Please treat as a substitute elevation plan

Please find attached a copy of the revised site plan, drawing number 20011/2.01 revision C and drawing 2.02 revision A. I would be grateful if you could substitute these for the previous versions.

Please can you let me have a revised site plan and elevation plan indicating native tree planting along the southern boundary as discussed, by Wednesday next week?

DATE 11.02.2020	SCALE 1:100	DRAWN BY MF
JOB NO. 20011		CHECKED BY _
DRAWING NO. 2.02		REVISION A

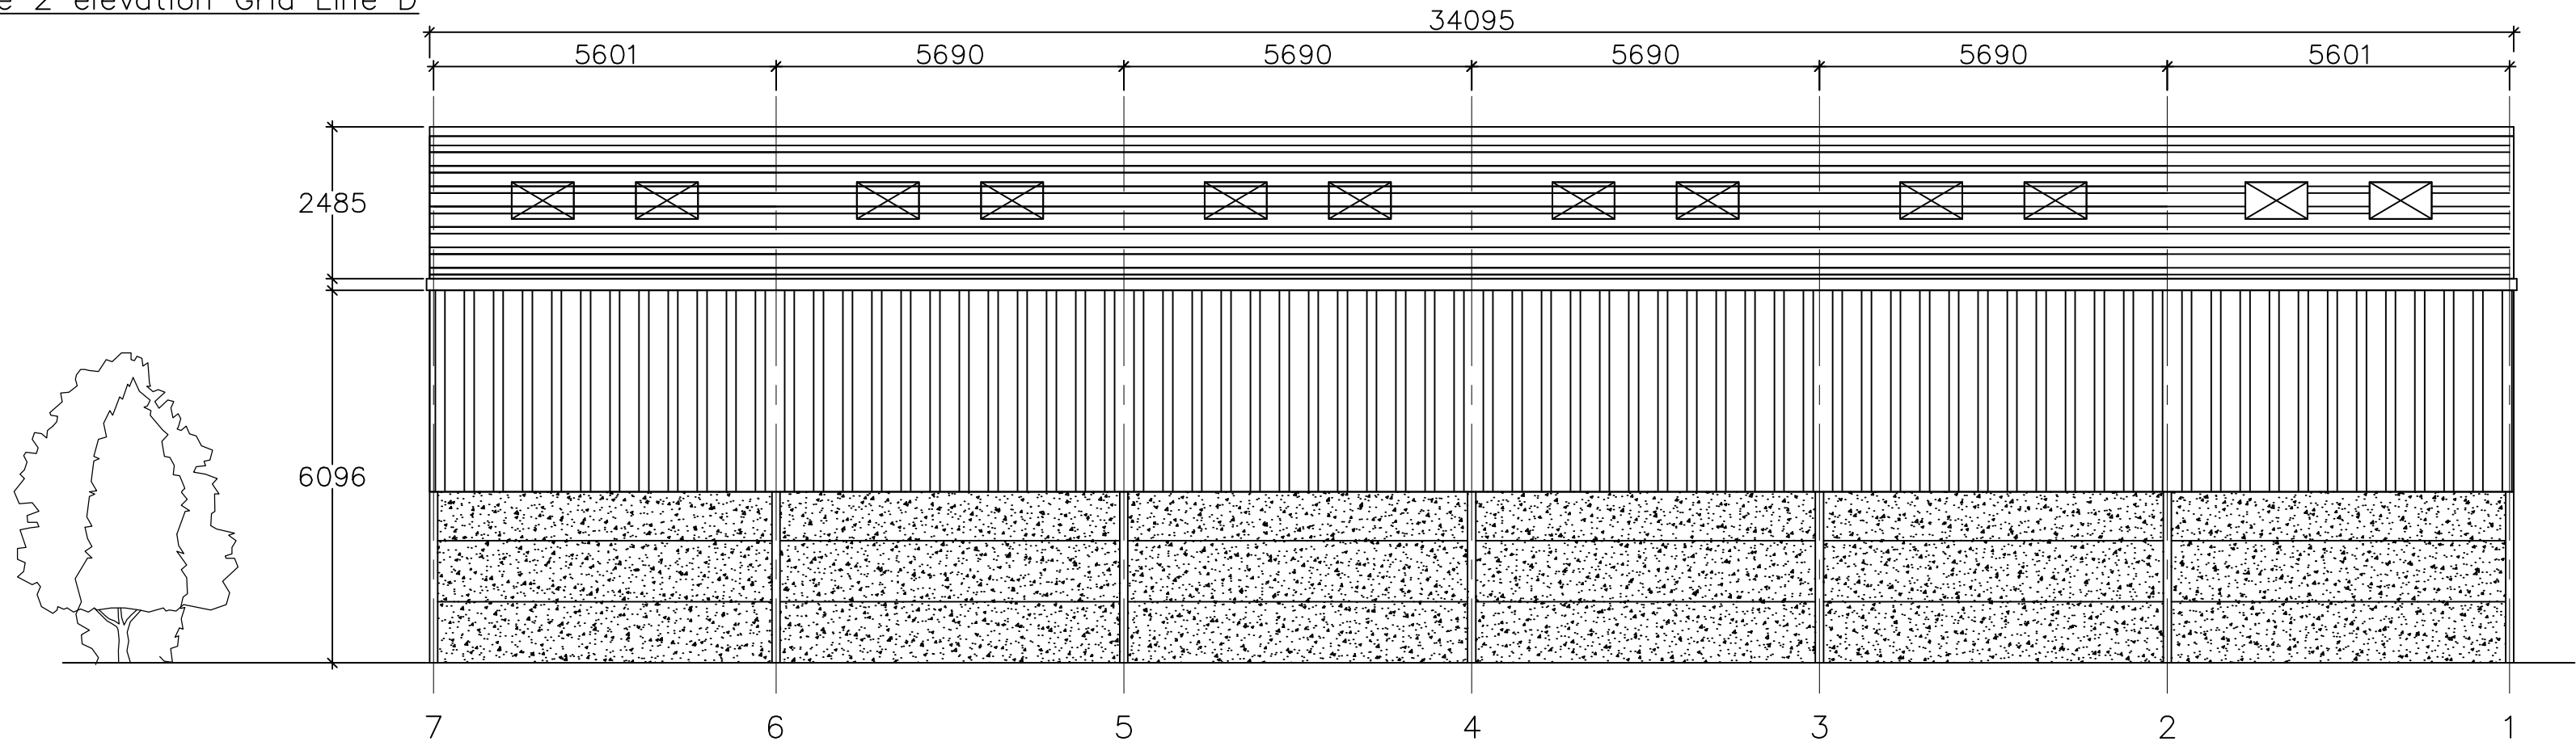
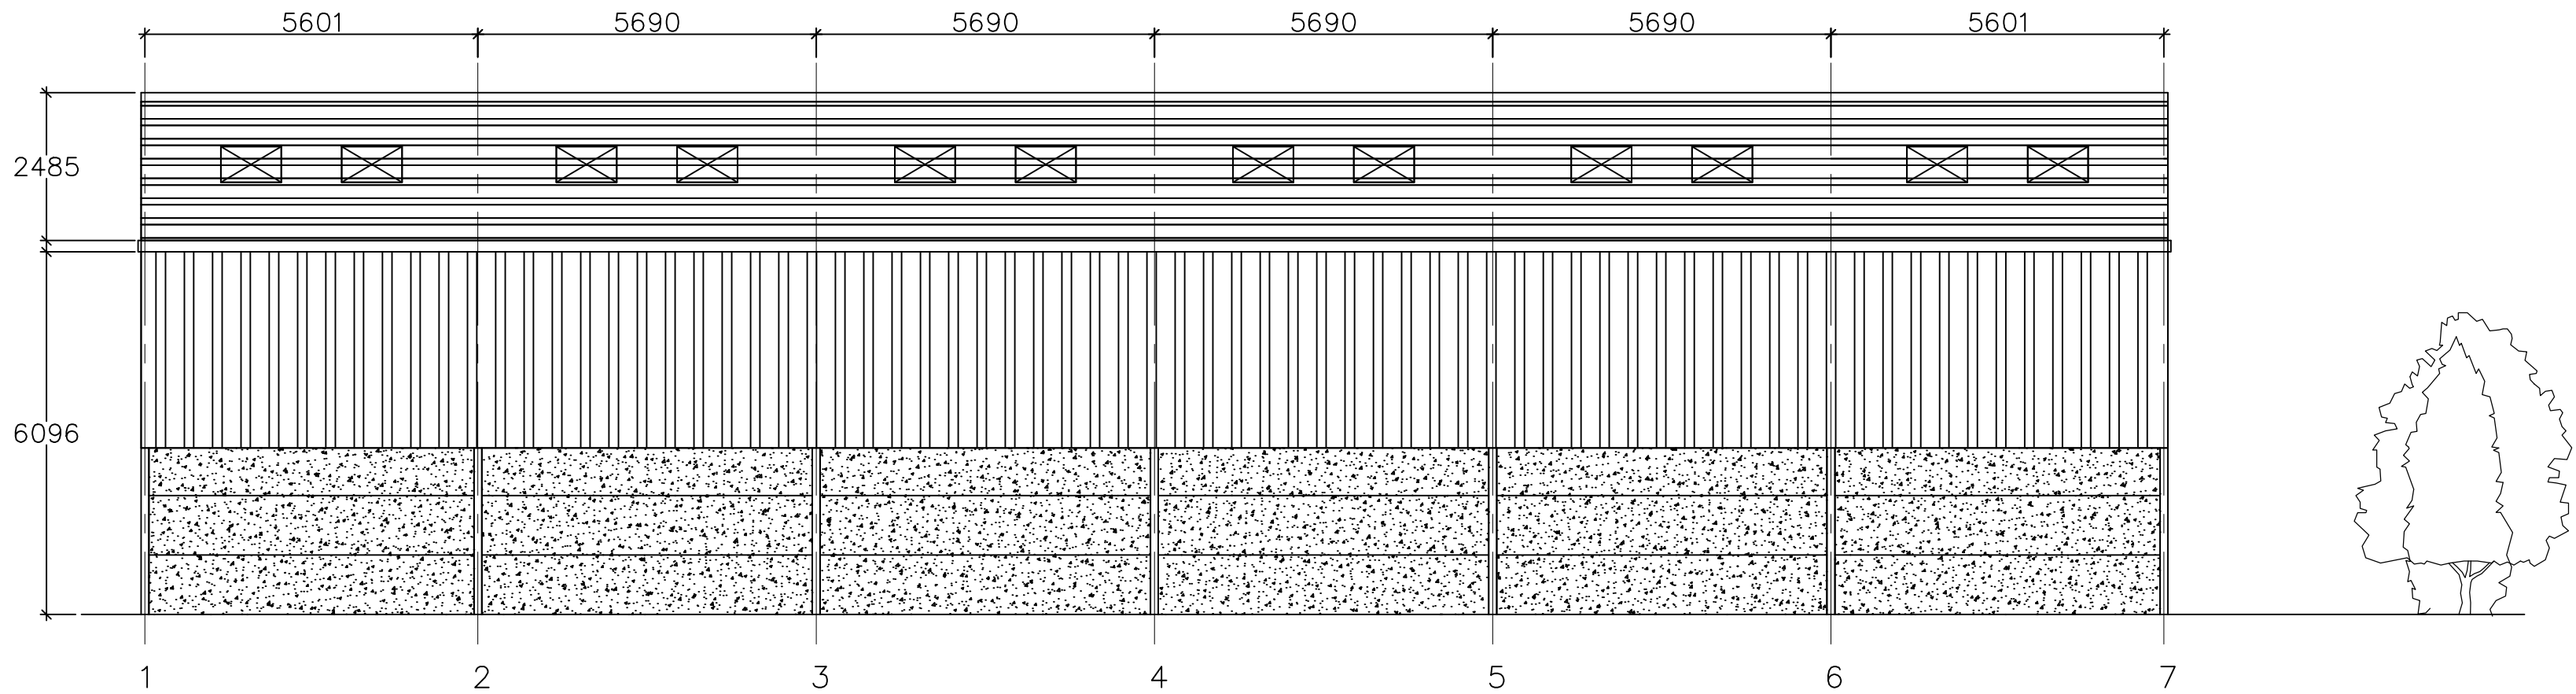
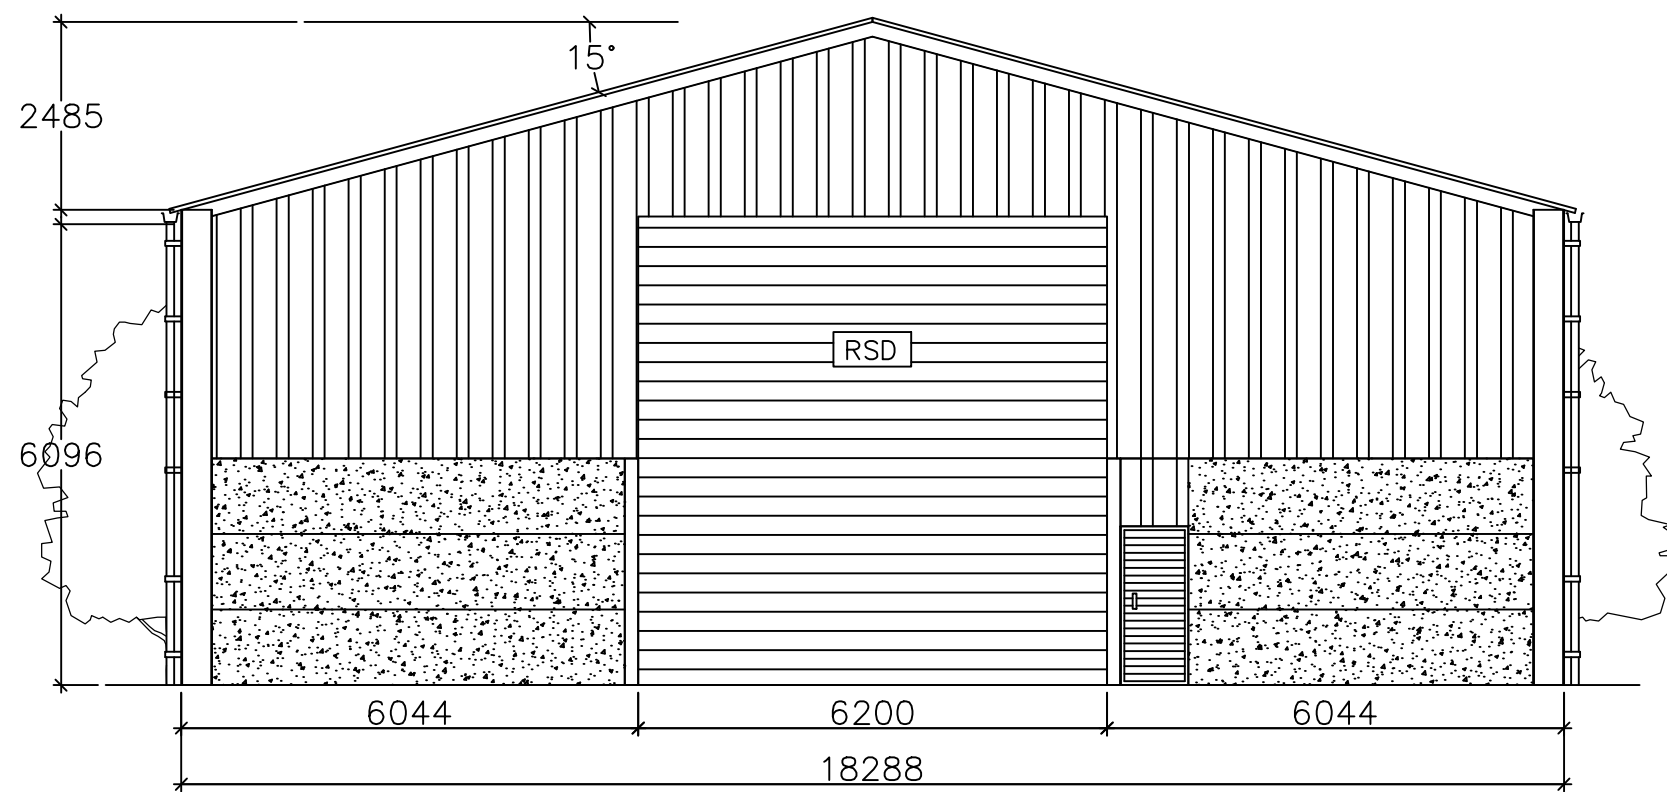
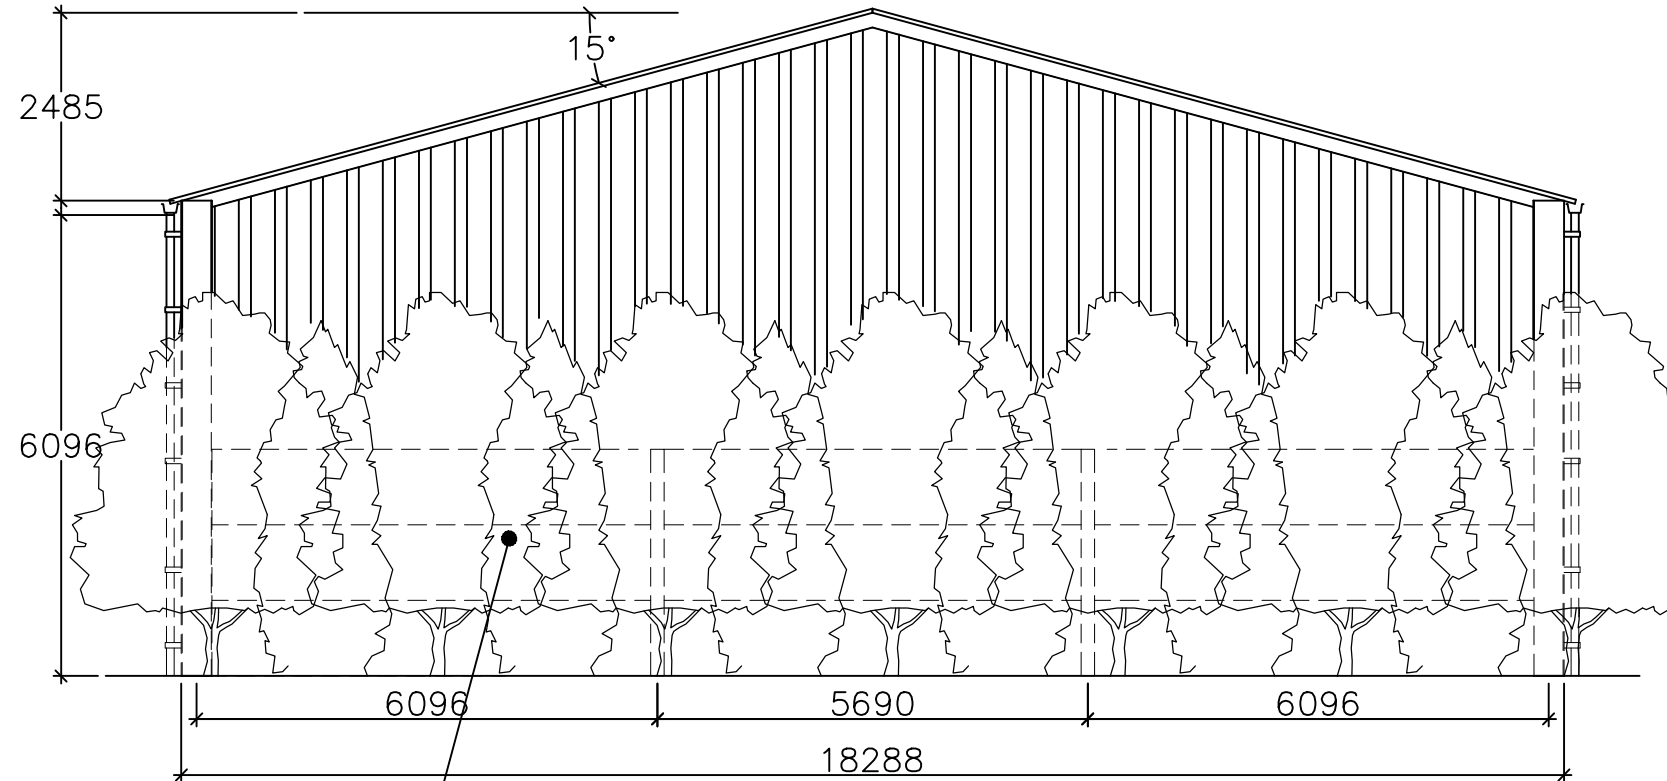
I have reconsulted the Ecologist based on the details submitted and await her response. In the meantime I would appreciate receipt of a revised site plan indicating the provision of native planting along the south elevation of the barn.

DRAWING TITLE
**Existing Location and Block Plan
PLANNING ISSUE**

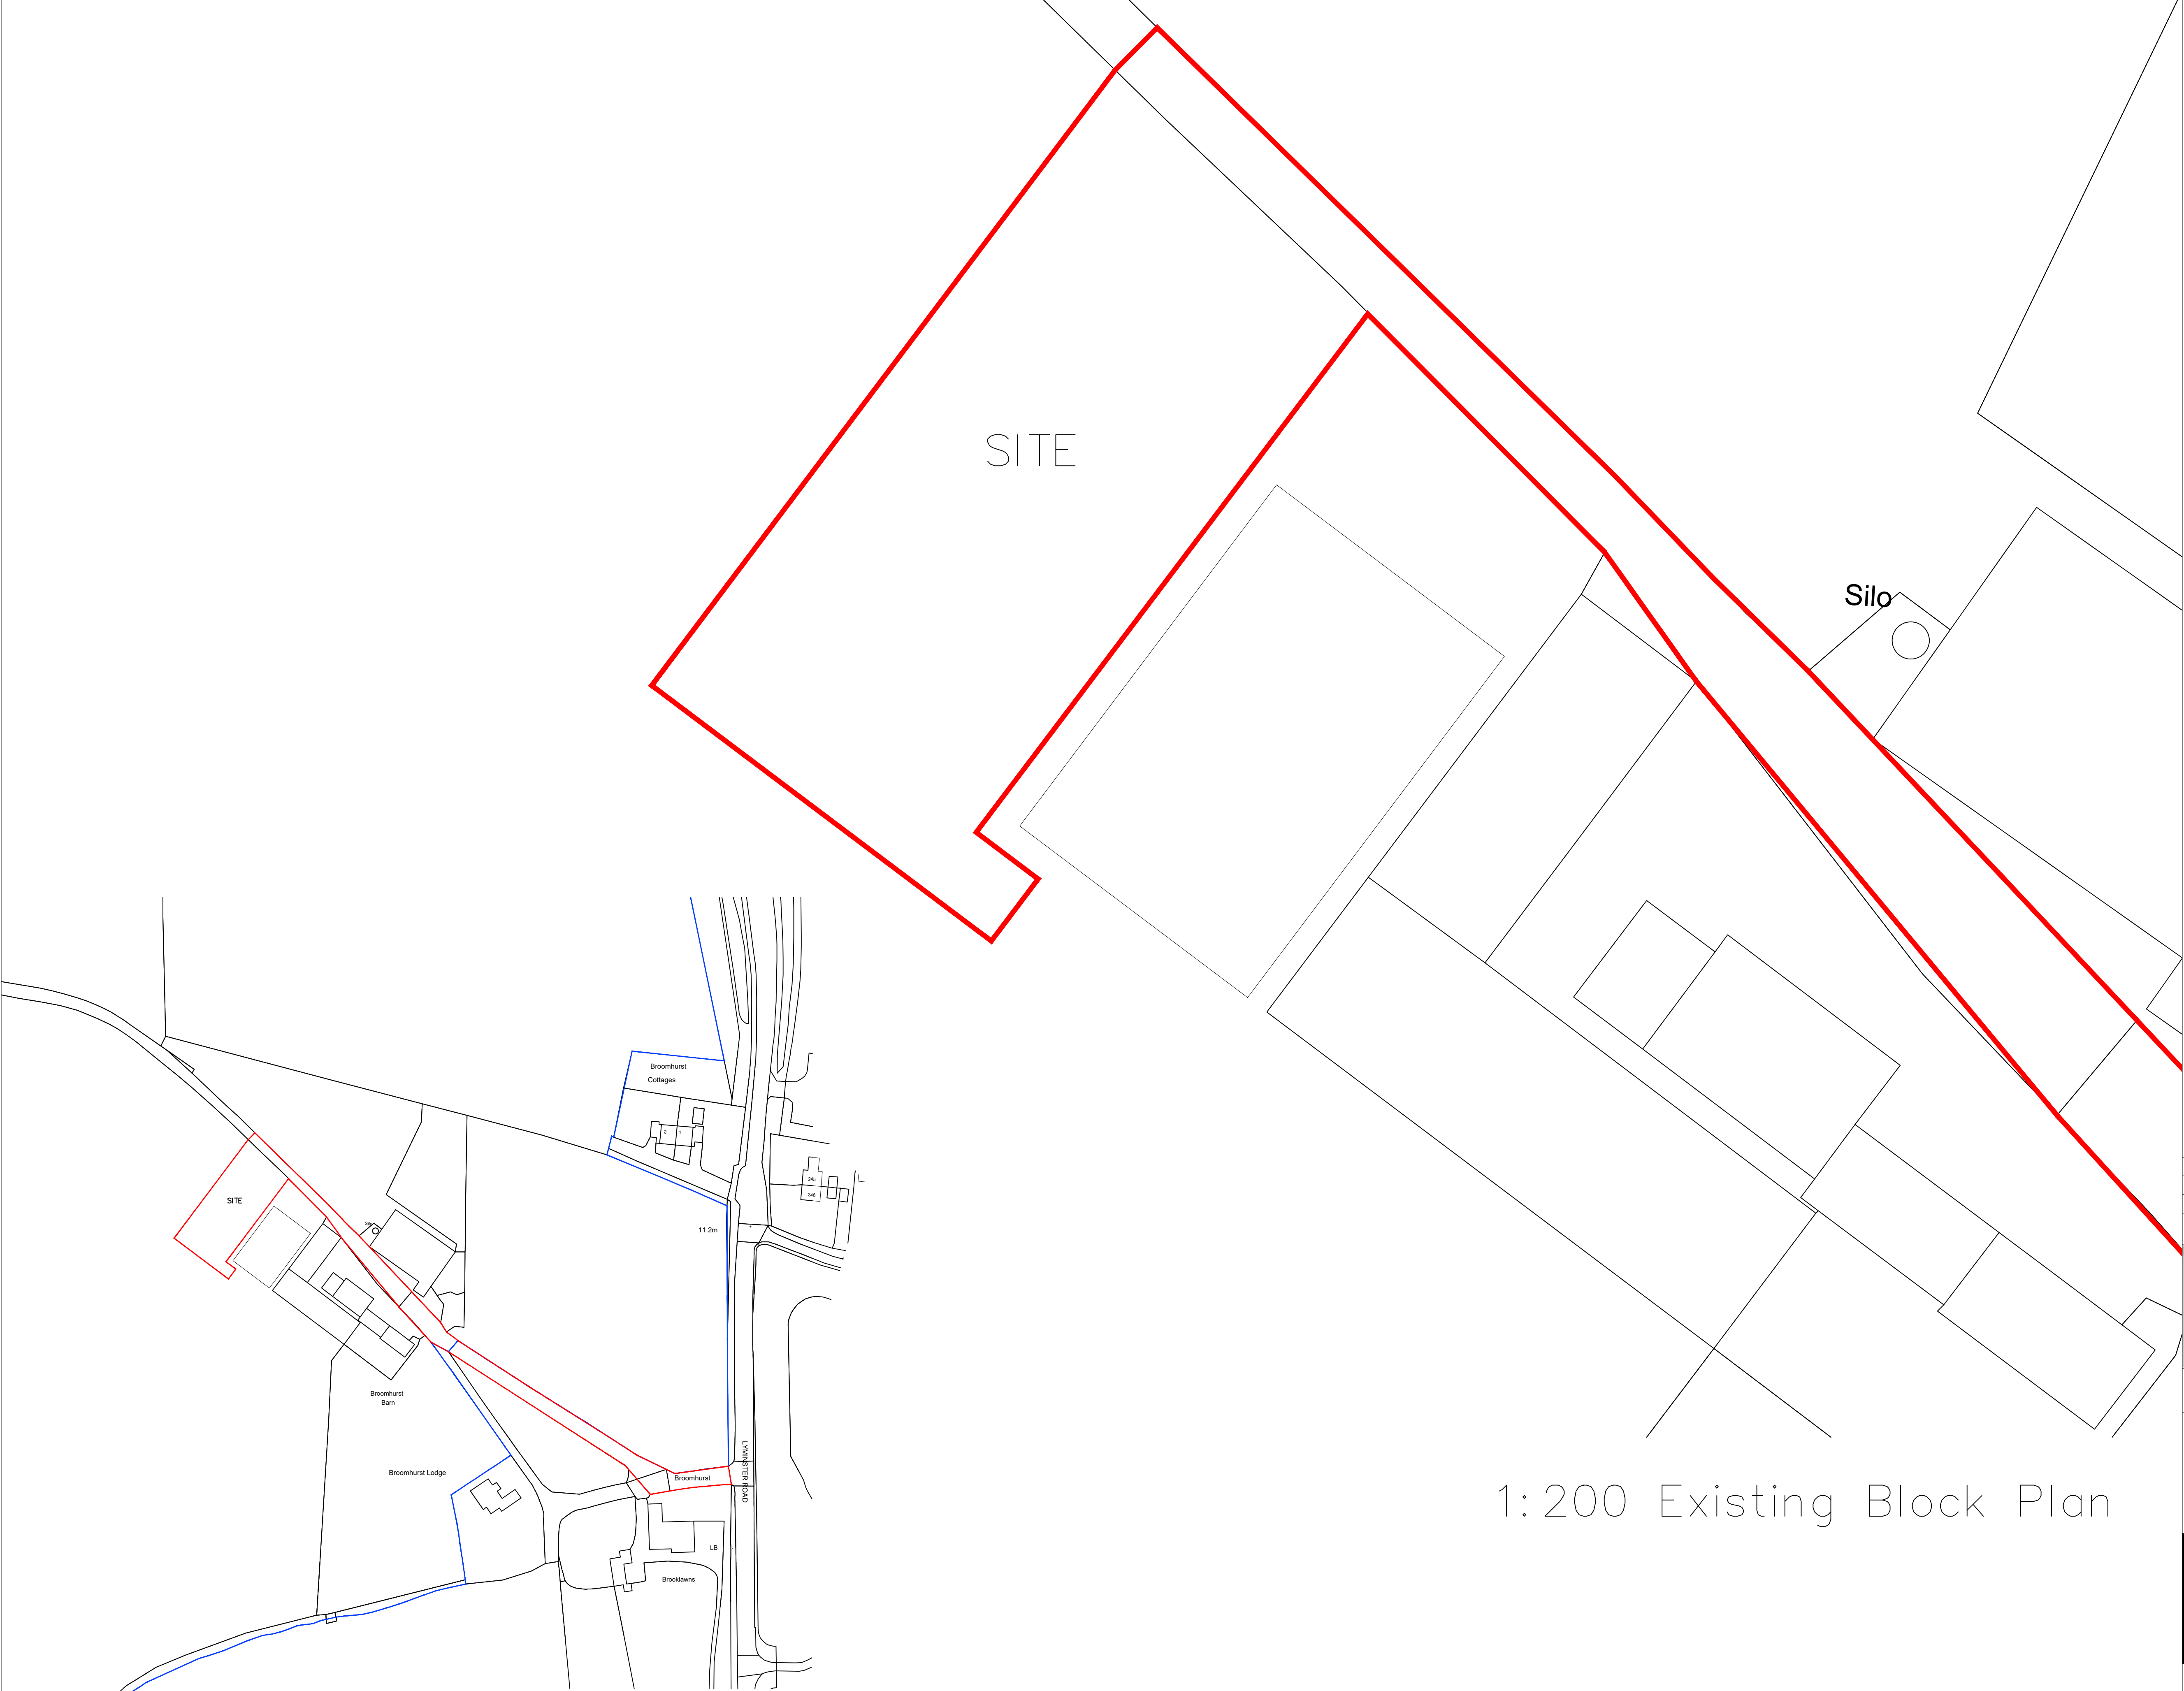
I have discussed the amended red edge to facilitate tree planting with my Team Leader and we can accept revised plans without the need for re-advertising.

Is there no option to reduce the width/length of the building slightly so that tree planting can be included within the red edge? Or to move the building forward or sideways within the red edge? A reduction in size would help to address our concerns and those of the Parish.
